Submissions in response to Exhibition of the Construction of 2 residential flat buildings varying in height between 4 and 7 storeys and containing 75 apartments, basement car parking for 81 vehicles and strata subdivision – Lot 104, Precinct C, 42 Walker Street, Rhodes MP05_0043

RE: Major Project Application MP 05 – 0043 42 Walker Street, Rhodes (Lot 104)

NORTH ELEVATION BUILDING 2

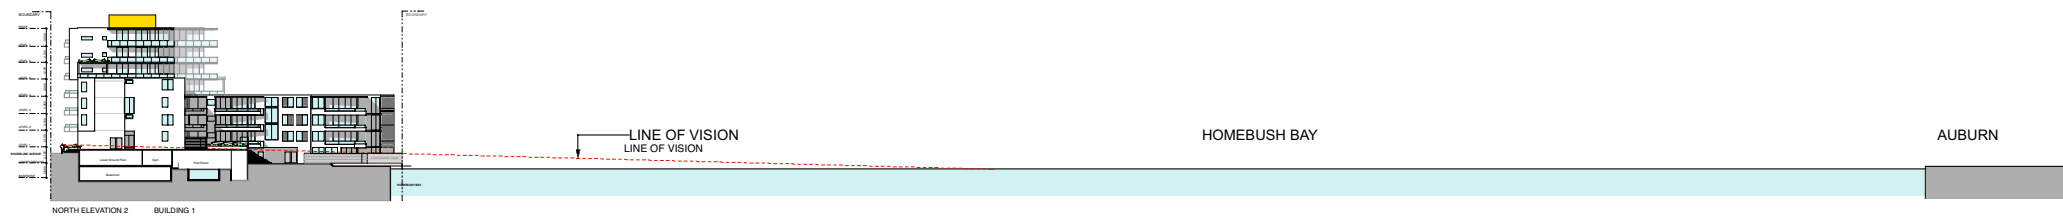
It is clear from the submitted montages that the proposed development is excessively bulky and will create an adverse bulk and scale impact on the waterway, which is unsatisfactory (see also elevation Plan 16 DA). The northern building, it is considered, would benefit from a reduction of one storey to make it compliant and to reduce the impact on the waterway.
